Application Ref:	3/2018/1148	 Ribble Valley Borough Council www.ribblevalley.gov.uk
Date Inspected:	08/01/19	
Officer:	RB	
DELEGATED ITEM FILE REPORT:		REFUSAL

Development Description:	Demolition of existing conservatory and erection of a single storey rear extension
Site Address/Location:	Wolfen Lodge, Fish House Lane, Chipping, PR3 2GR

Proposed Rear Elevation
 Block Plan and
 Location Plan
 DATE 08.08.2017

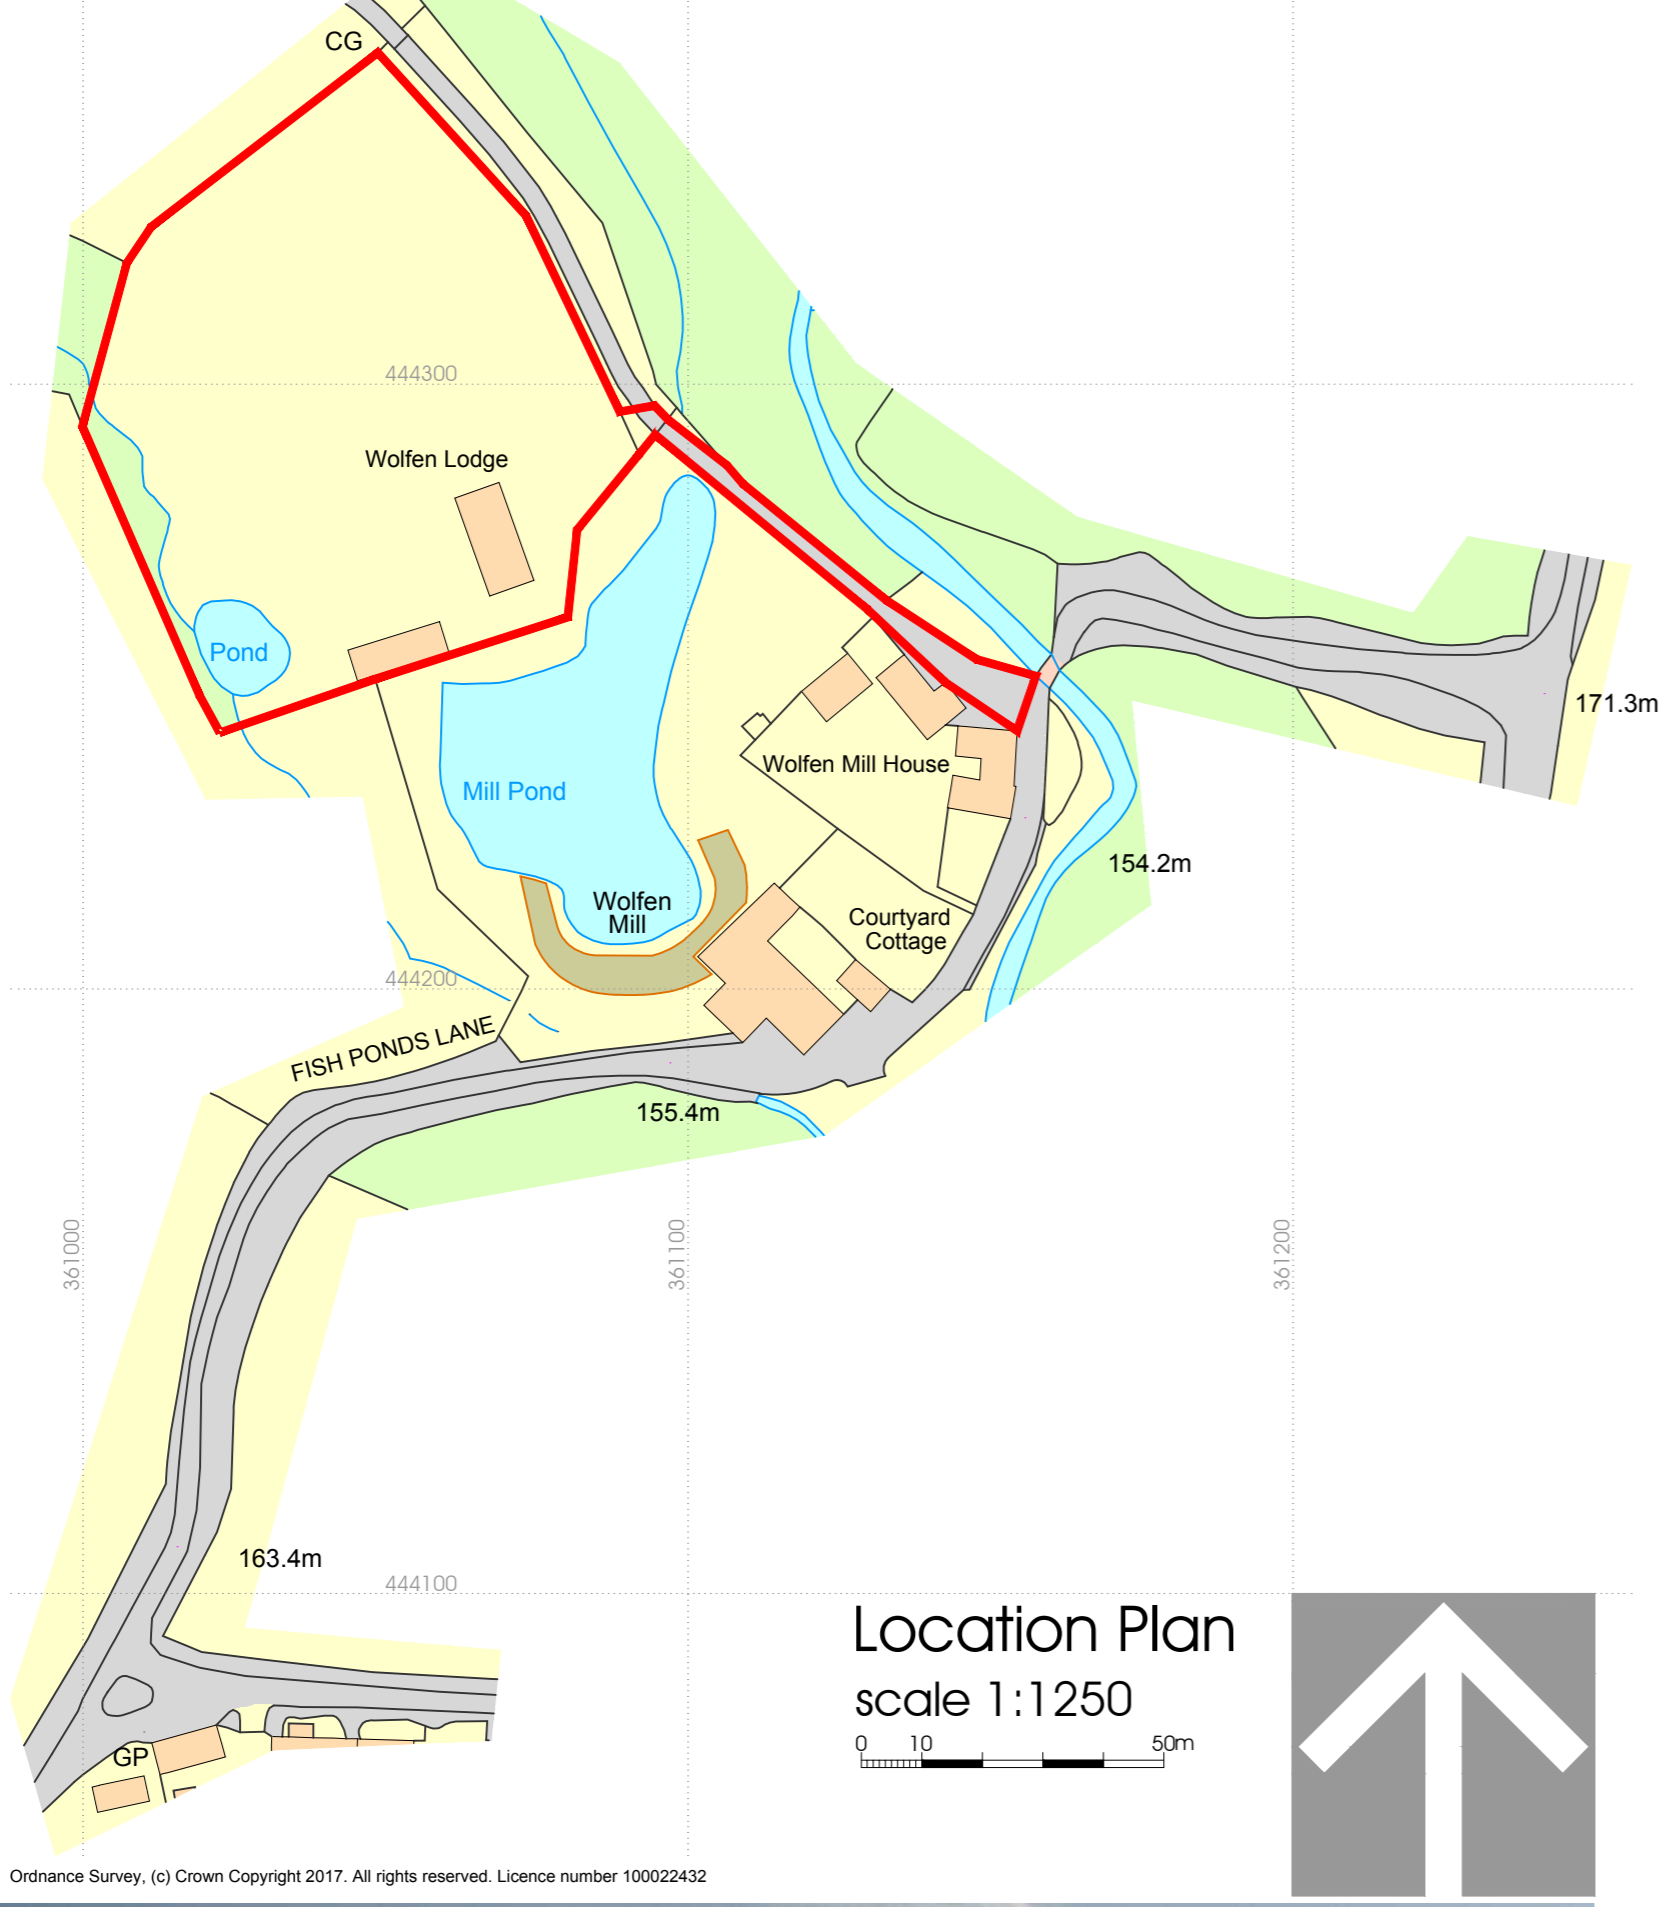
The proposed rear extension will project 6 metres rearwards of the dwelling and will have a maximum height of 5.6 metres, covering up 4 of the first floor windows on the rear elevation of the property. The rear elevation of the extension would be mainly glazed consisting of aluminium sliding doors with 12 glazed roof panels in the roof slope along with a flue.

Agricultural buildings are characterised by a limited number of window and door openings. Whilst it is noted that the conversion of the barn has resulted in the creation of a number of additional window and door openings, creating somewhat ordered and symmetrical fenestration of the existing building at the rear. The proposed extension seeks to introduce large aluminium glazed doors to the rear elevation and roof slope. This would not be in keeping with the original building or respect the existing fenestration details in particular the ratio between solid wall and window. The openings would not sit comfortable with the building and do not reflect local vernacular or style.

With this in mind, it is considered that the proposed extension would significantly detract from the simplistic character of the original barn by introducing an overly domestic extension that bears little resemblance to the present barn.

The proposed rear extension would detract from the character and appearance of this non-designated heritage asset by introducing an overly domestic extension to the rear elevation of the barn which would be detrimental to the visual amenity of the open countryside and AONB. The proposal is therefore considered to be contrary Key Statements EN2 and EN5, and Policies DMG1, DMG2 and DME4 of the Ribble Valley Core Strategy, as well as national guidance contained within the National Planning Policy Framework.
